The Planning Inspectorate
Yr Arolygiaeth Gynllunio

Acceptance of Applications Checklist

East Anglia TWO Offshore Windfarm Section 55 Acceptance of Applications Checklist

East Anglia TWO Offshore Wind Farm

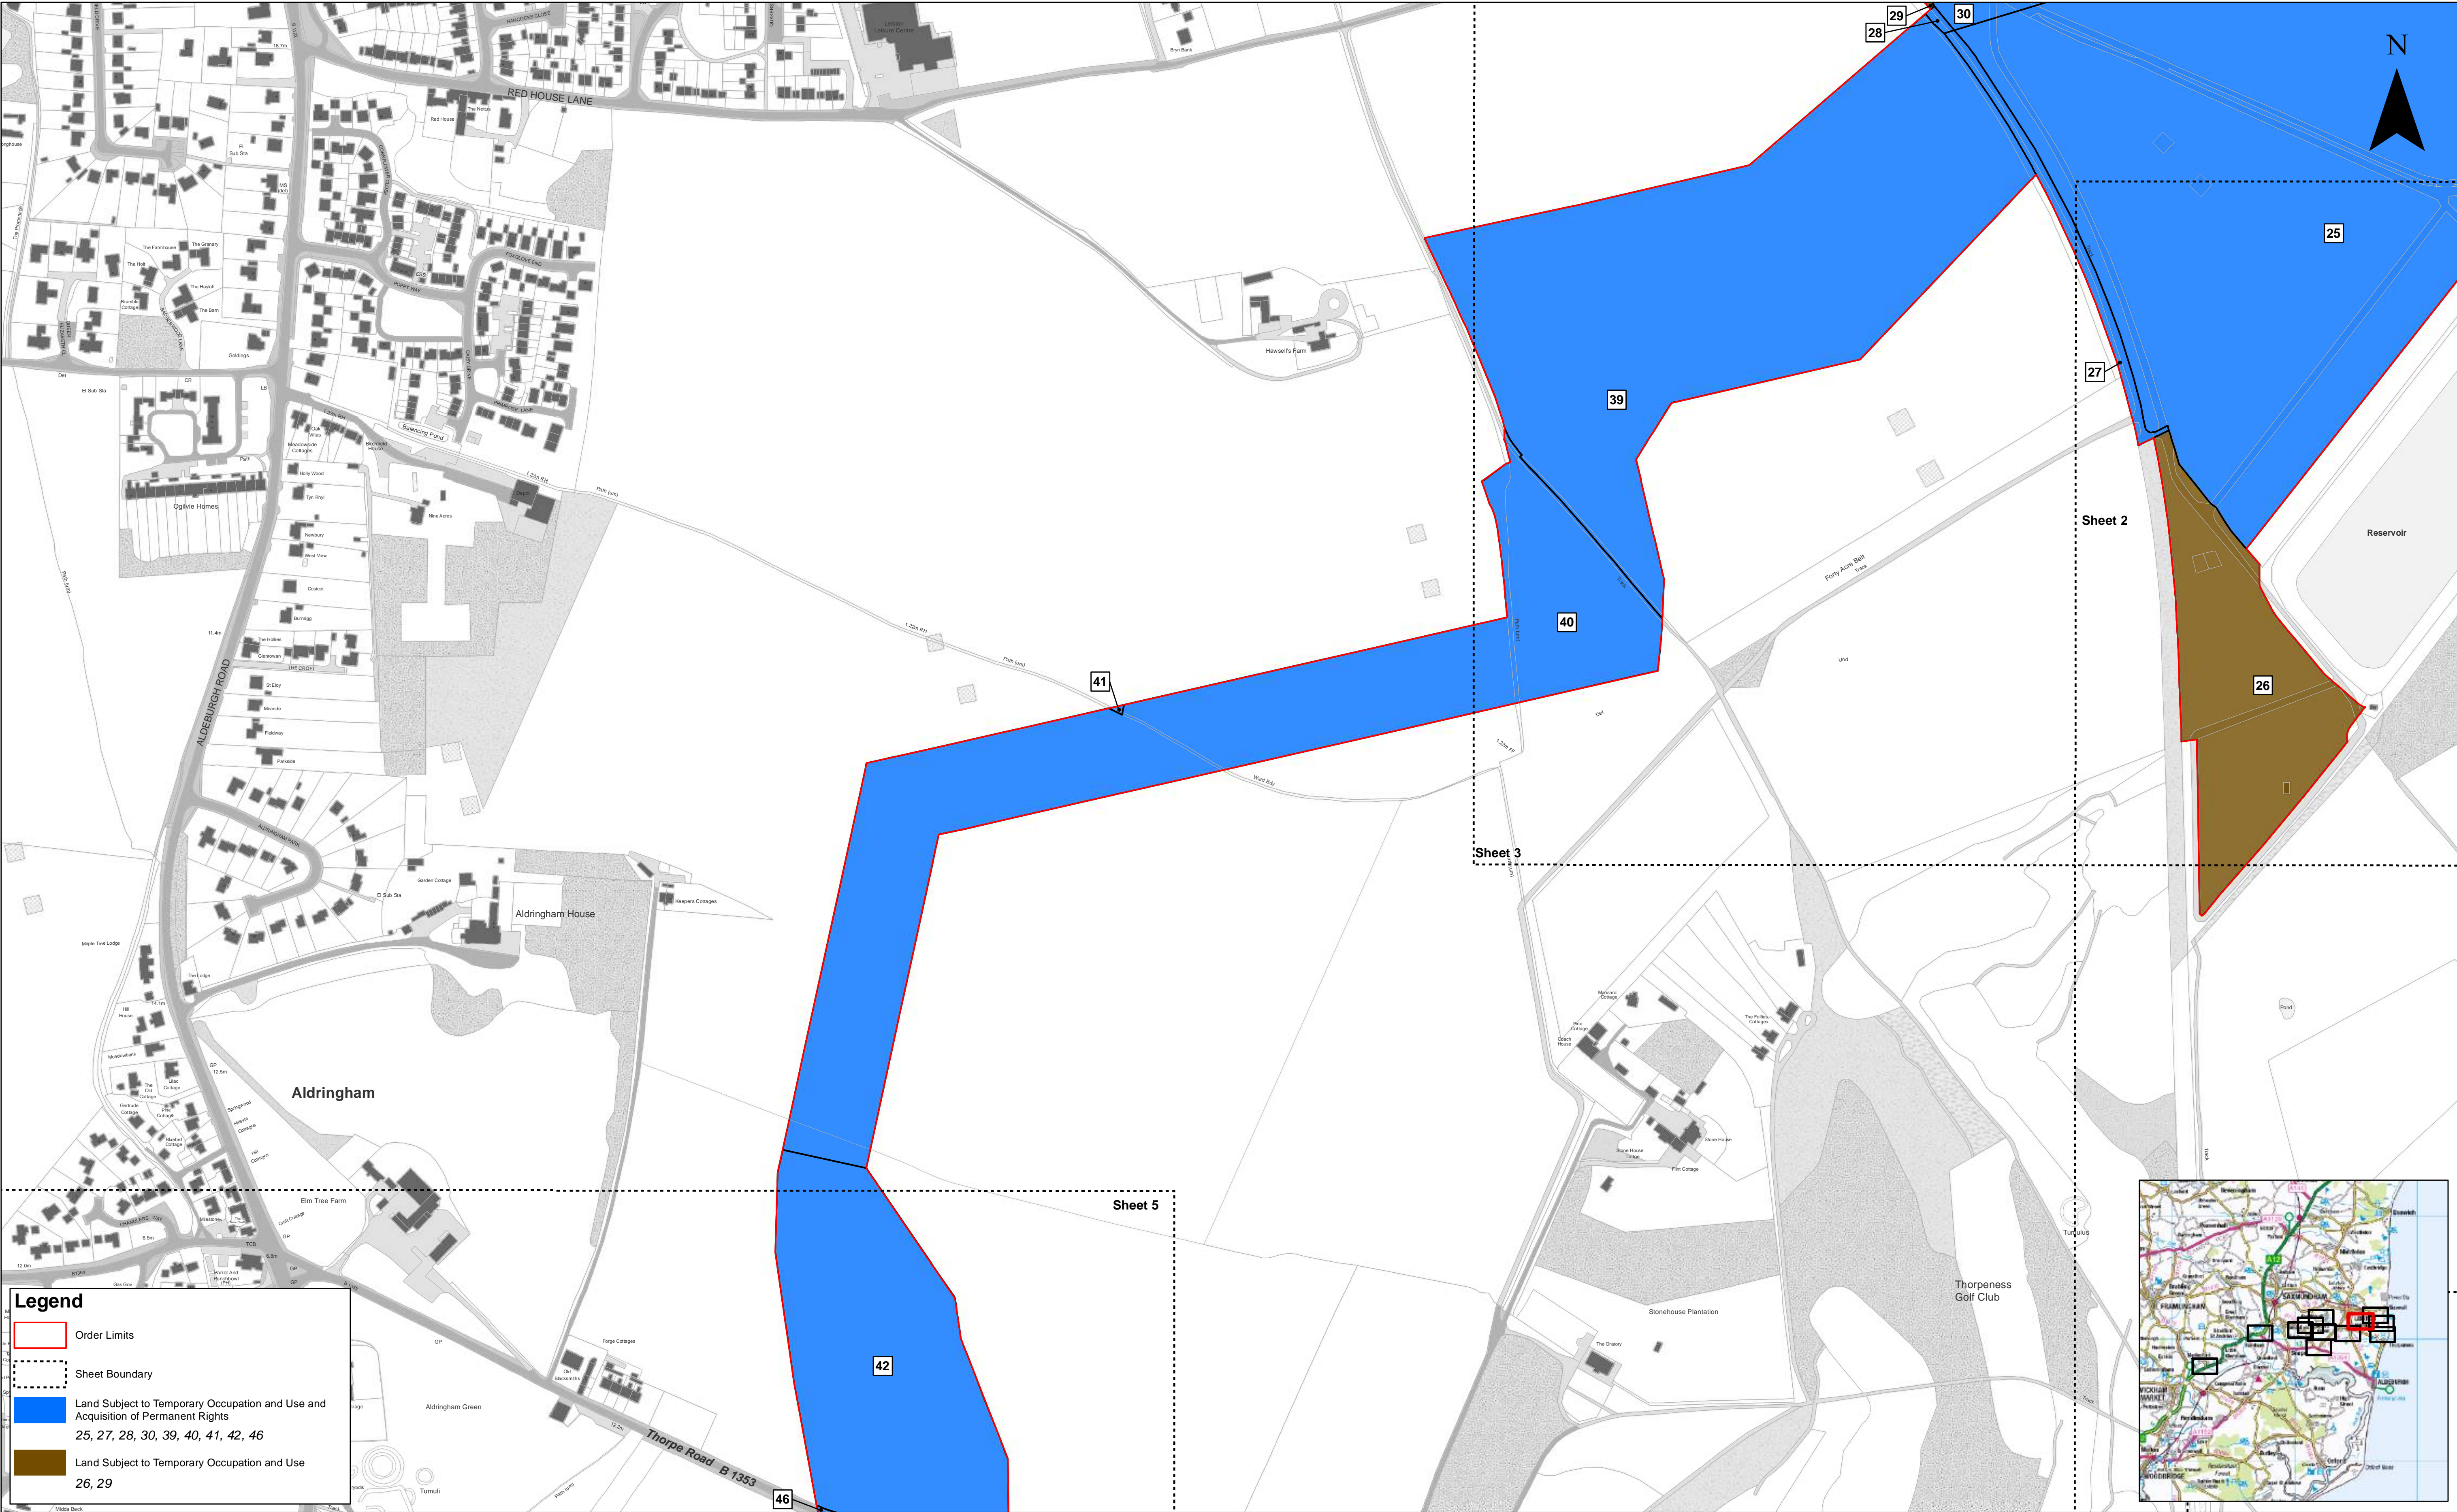
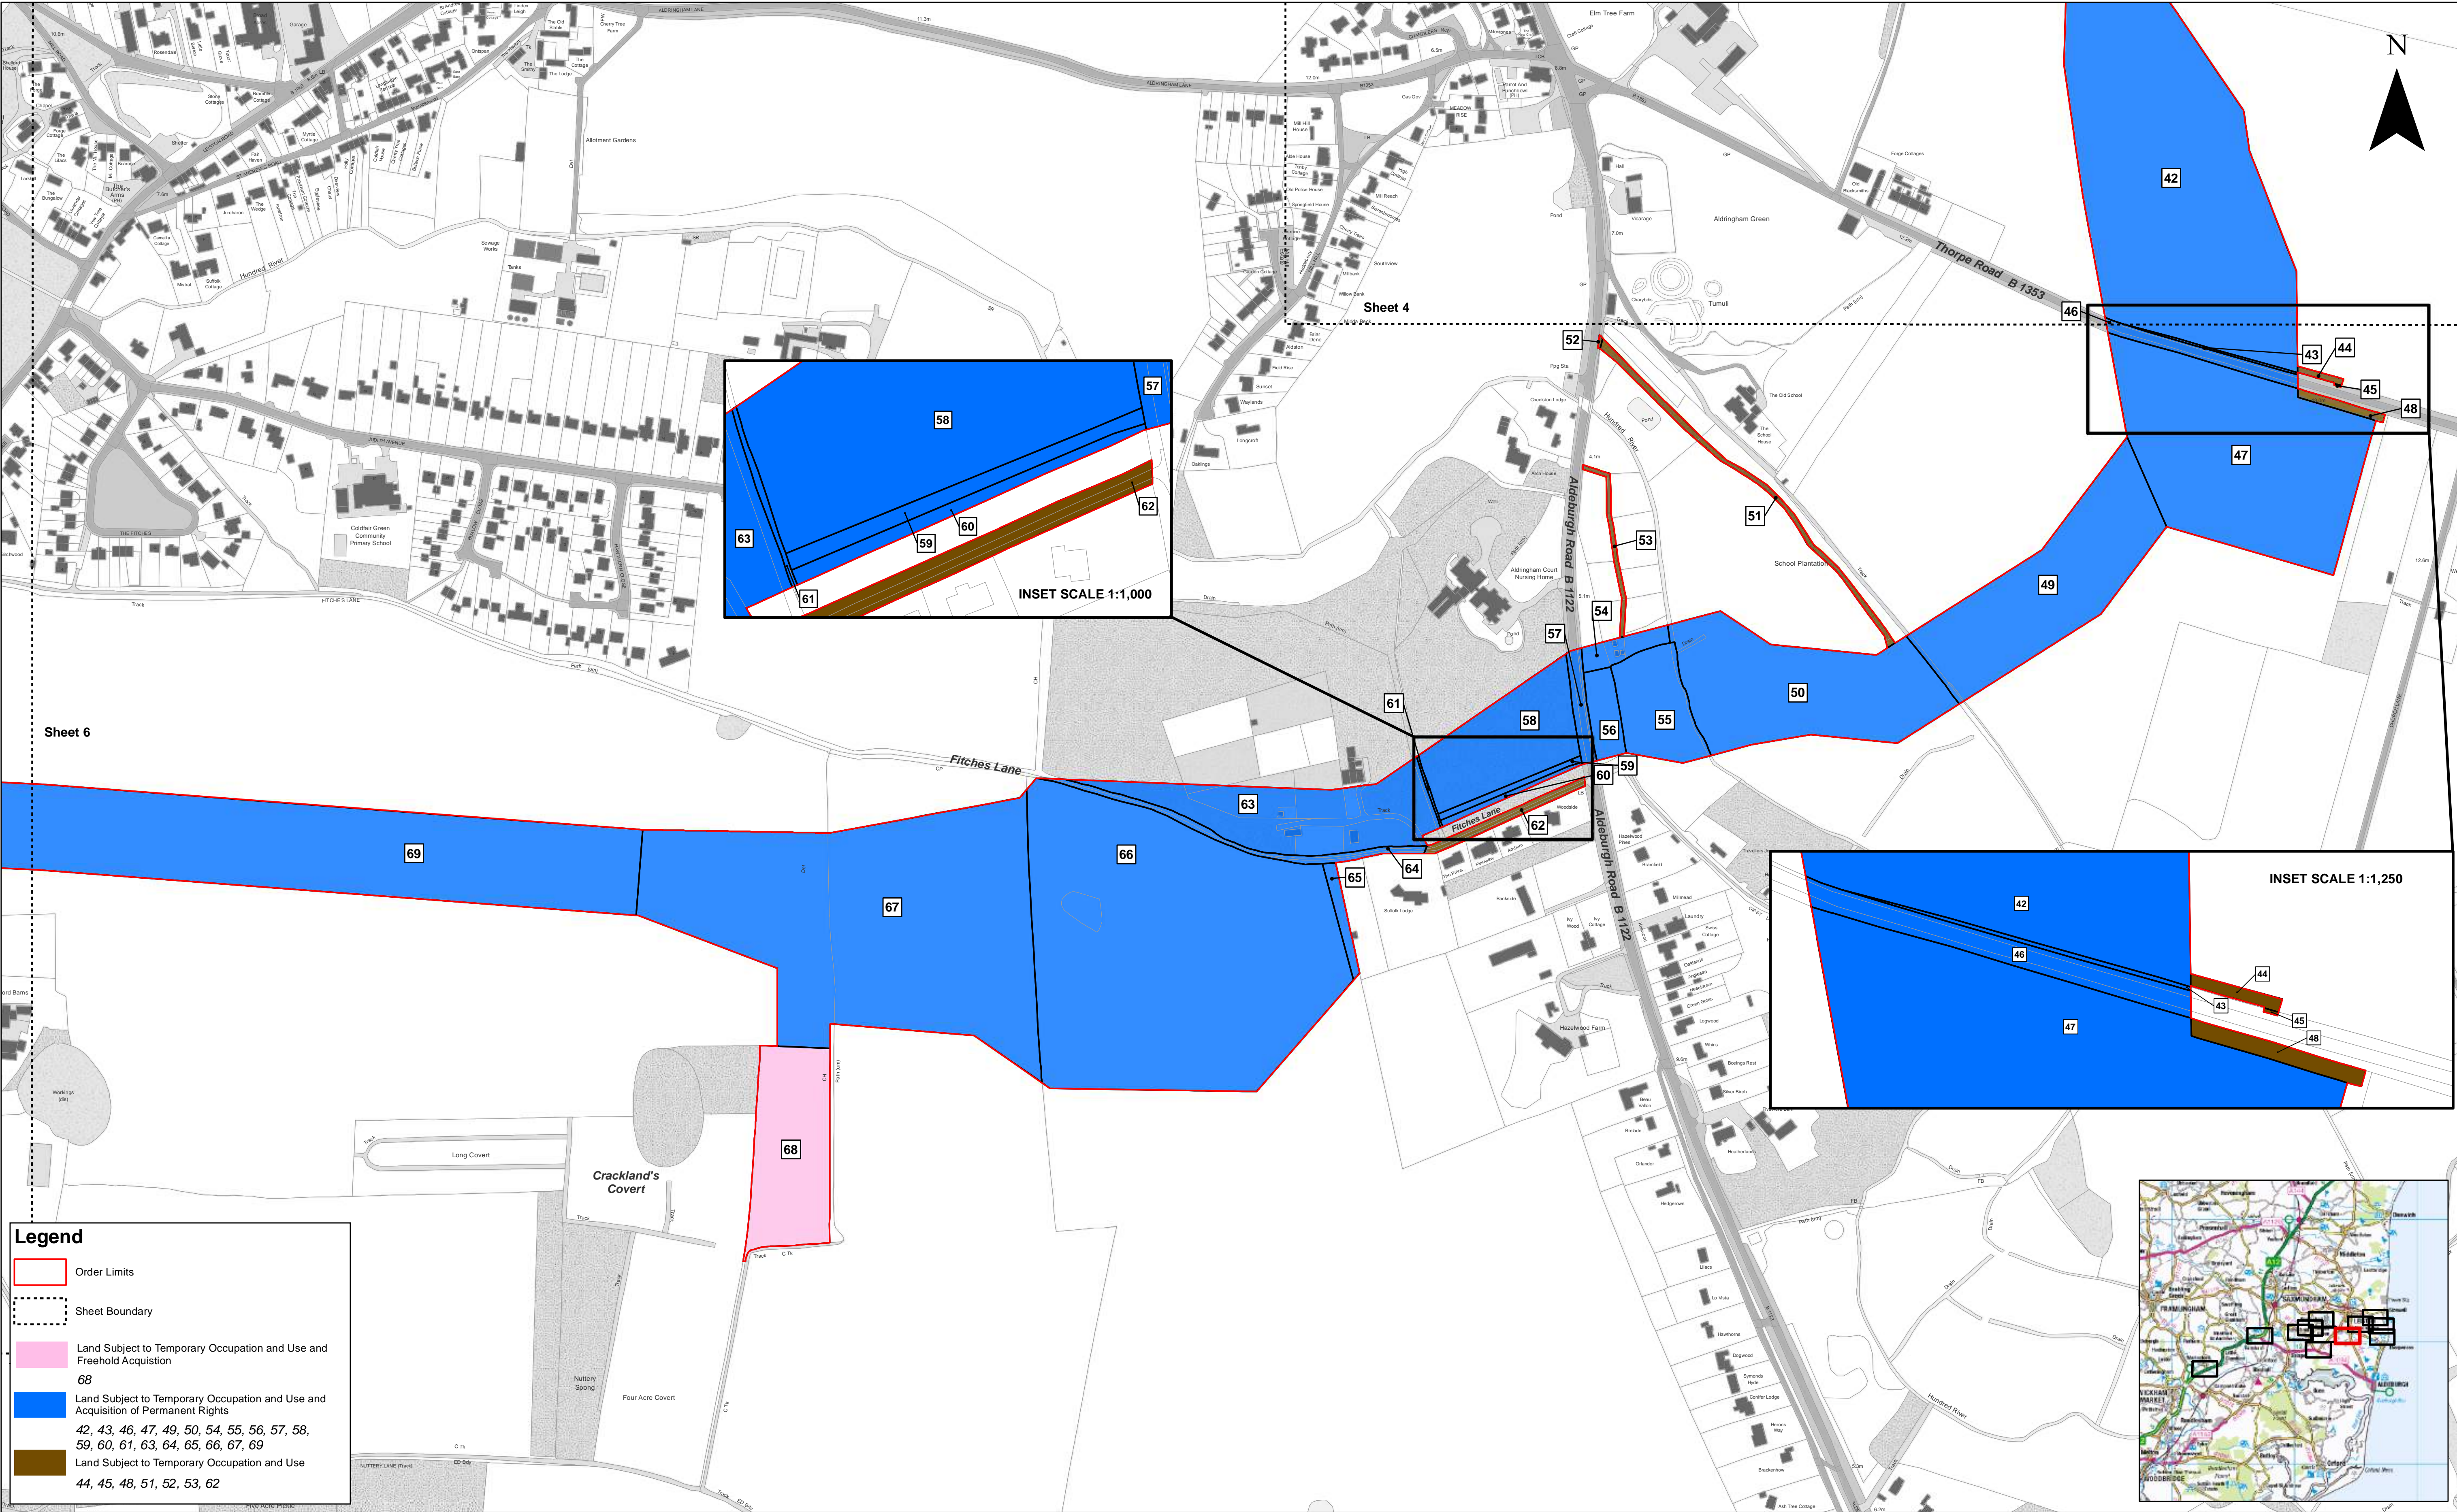
- A separate key plan has not been submitted under APFP Reg 5(4). The **Land Plan (Doc 2.2)** comprises 13 sheets. Sheet 1 is labelled as Land Plans sheet 1 of 13. This appears to be a Key Plan (though not labelled as such) which shows the relationship between the different sheets. It also shows Sheet 2 and Sheet 3 which are sectional type key plans. The individual Land Plan sheets run from Sheet 4 – 13. The Land Plan set does not utilise the same map base as the other submitted plans and the sheet layout is different.

- Not all of the names used to describe the location of land in the Book of Reference are noted on the Land Plan, ie Sizewell Estate, Sizewell Gap, Grimsey's Lane, Blackheath Estate, Redhouse Farm and Knodishall Hall.

- Road names are an important aid to the identification of land and should be larger and clearer.
- The description of Plot 65 in the Book of Reference is 'west of Fitches Lane'. Plot 65 appears on the plan to be southeast of Fitches Lane. The same issue is noted for Plot 66.
